Date: 25/01/2021

Location: West Winds, Portsmouth Road, Ripley, Woking, GU23 6EW  
Regarding: Residential extension.  
Reference: 20/A/00417

**PROPOSED NORTH ELEVATION**

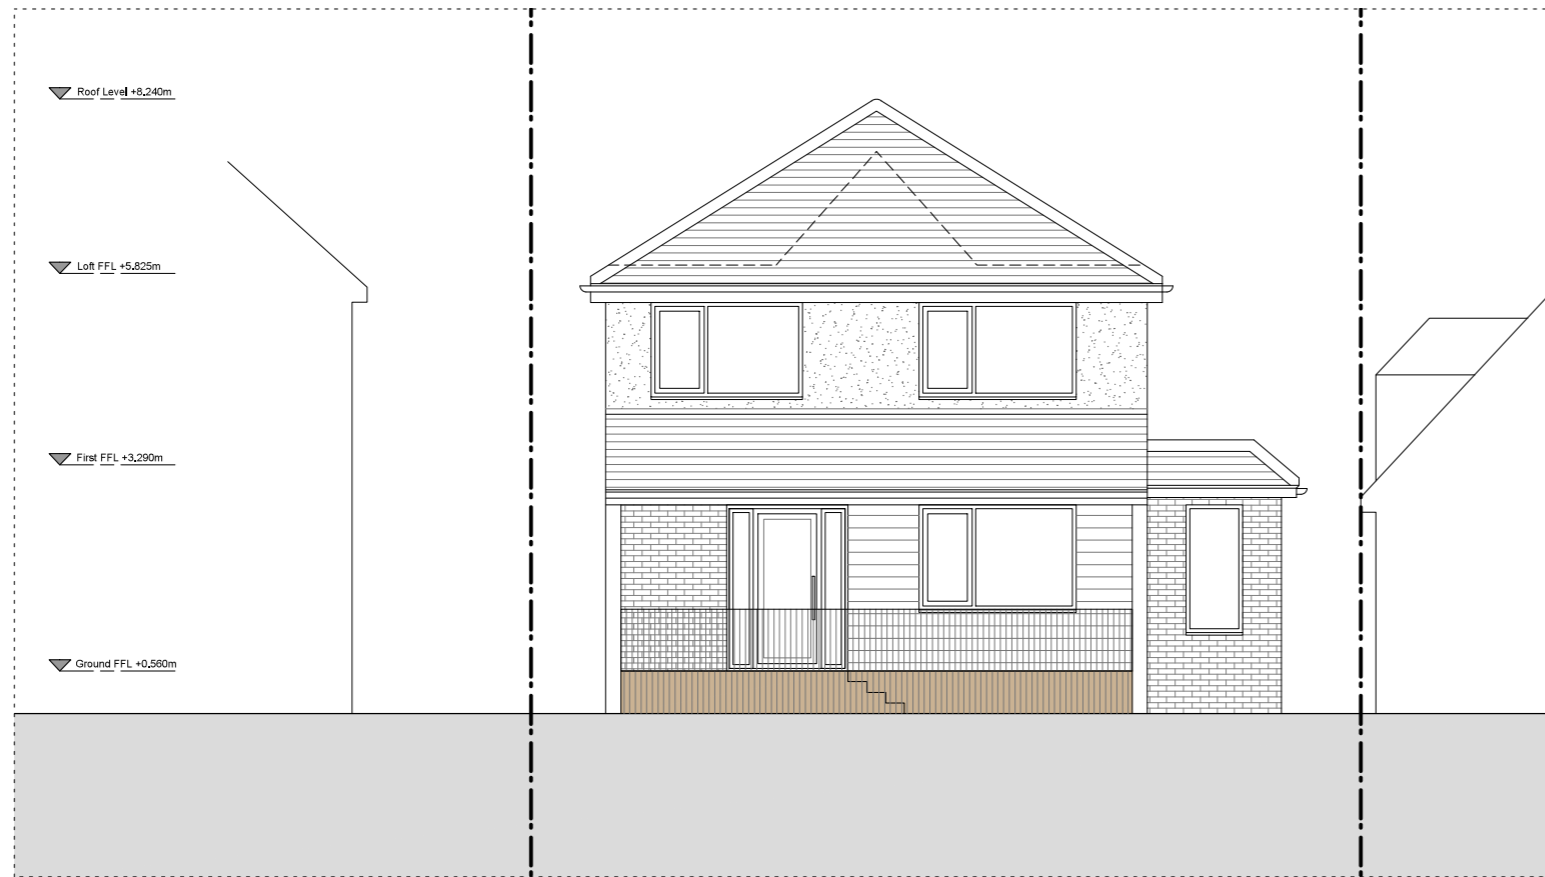
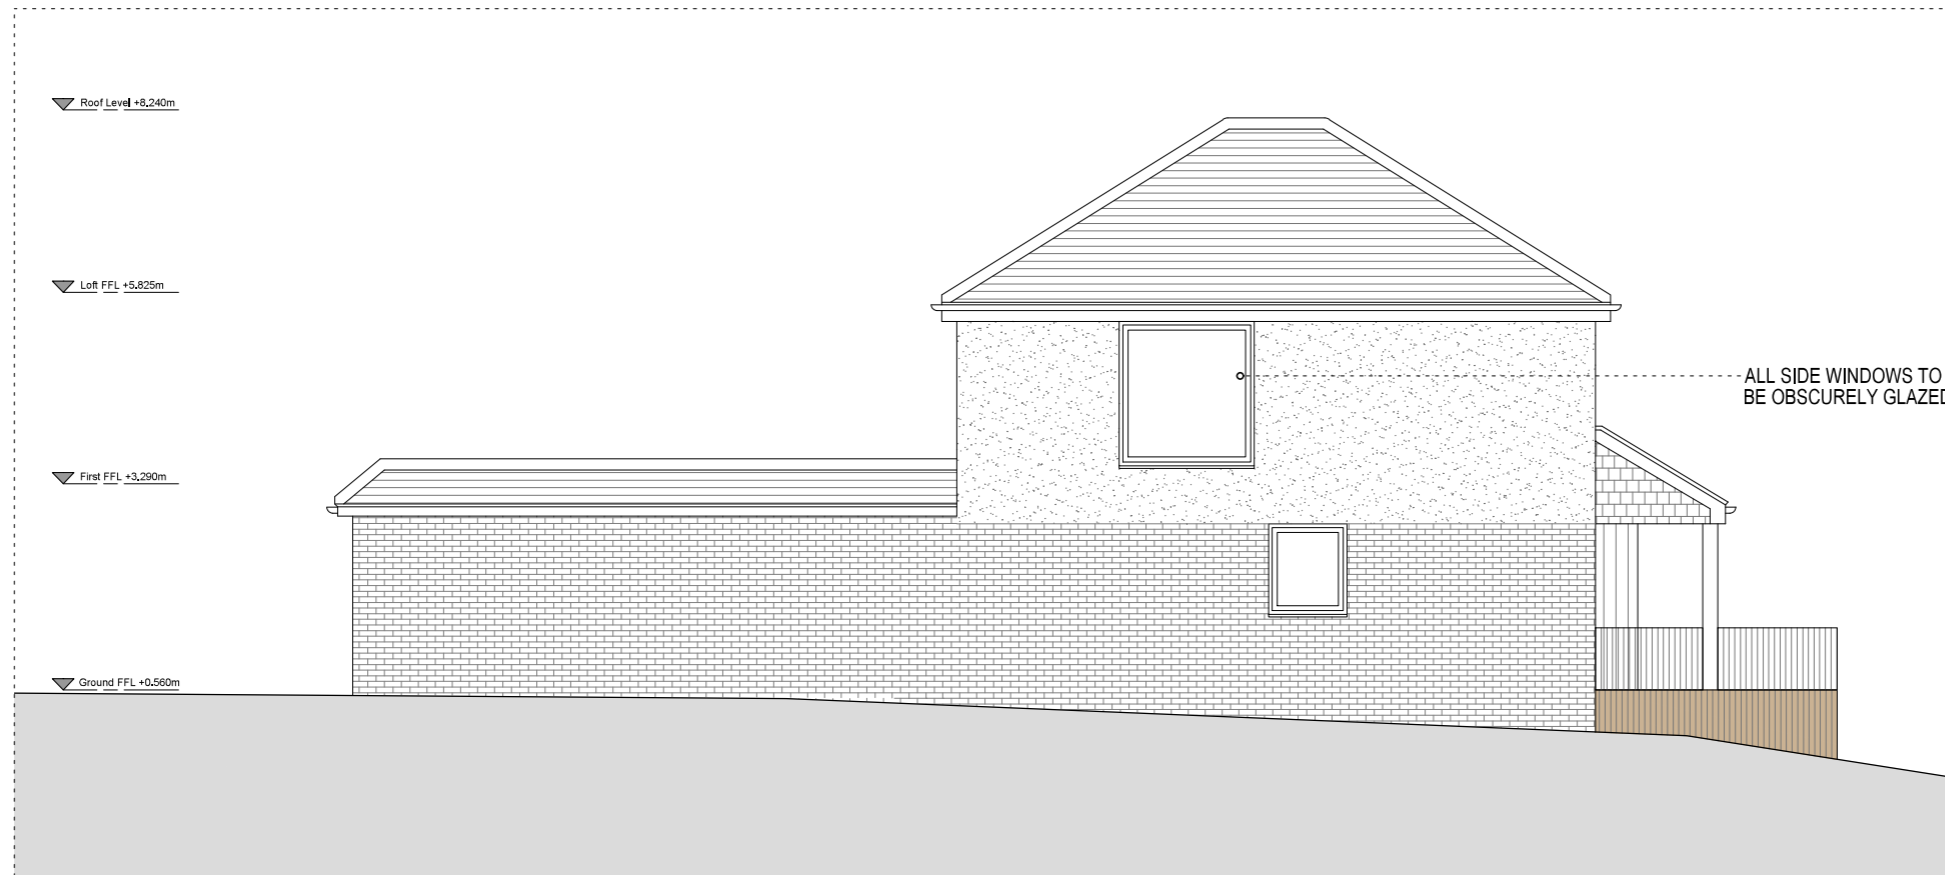
- As per the previously refused scheme, the proposal includes a large first floor window on its side (northern) elevation facing the neighbour 'The Retreat', serving a stairwell. It is noted that this would face directly towards the neighbours first floor landing window. Given that this window is annotated on the plans as obscurely glazed, it is my opinion that this would be acceptable.
- the submitted roof plan shows a total of four rooflights (one on each roofslope) however, these are not shown on the proposed elevations. In the event that an application is submitted you would need to ensure the elevations/roof plan accord with each other.
